REPORT UPDATE

Application No: LU/149/20/PL

LOCATION: Littlehampton Wave
Sea Road
Littlehampton
BN16 2NA

PROPOSAL: Installation of a 4m high timber sculpture shaped in the form of 3 No. waves, fixed to a concrete base. This application is not CIL Liable (Zero Rated) as 'all other development'.

Job Title LITTLEHAMPTON LEISURE CENTRE DEMOLITION & REINSTATEMENT	Dwg No.	L400/203/4
	Scale	1:100 @A4
	Drawn By	R.A
	Date	JULY 2020
Drawing TOTEM PLANTING

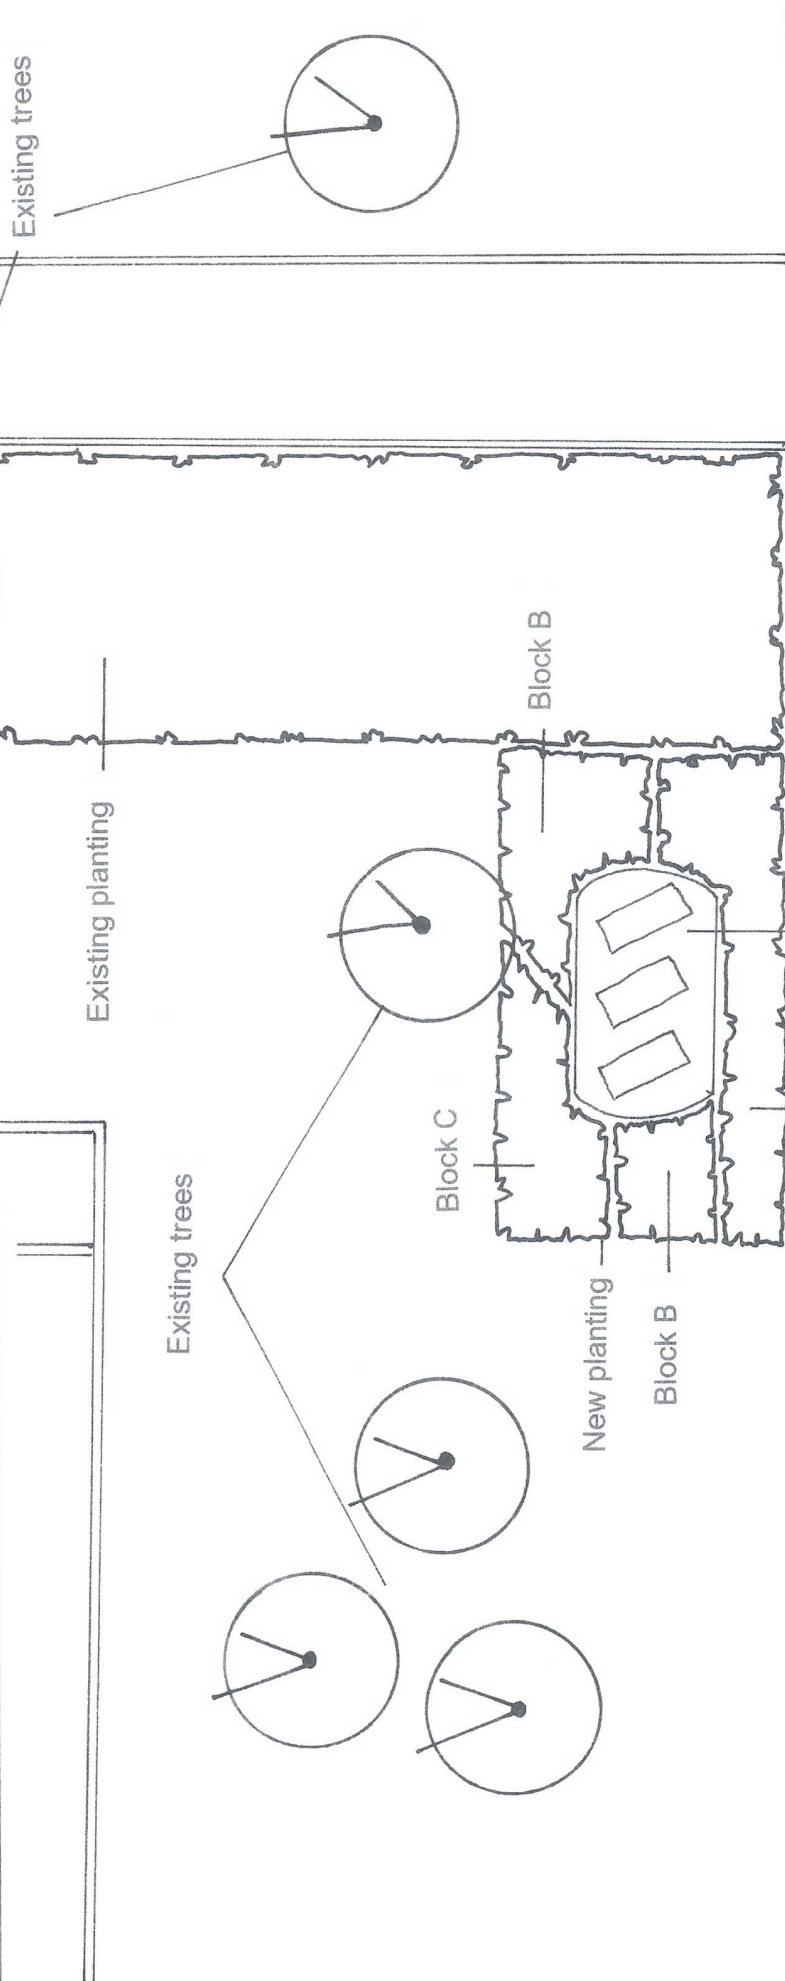
Landscape Officer - No Objection subject to the incorporation of planting at base level.

Further landscape provision of grasses and coast tolerant species to mirror the existing scheme are to be incorporated in the immediate surrounds of the slab base work so as to assimilate it into the surrounding landscape. The type of planting used will be controlled by condition.
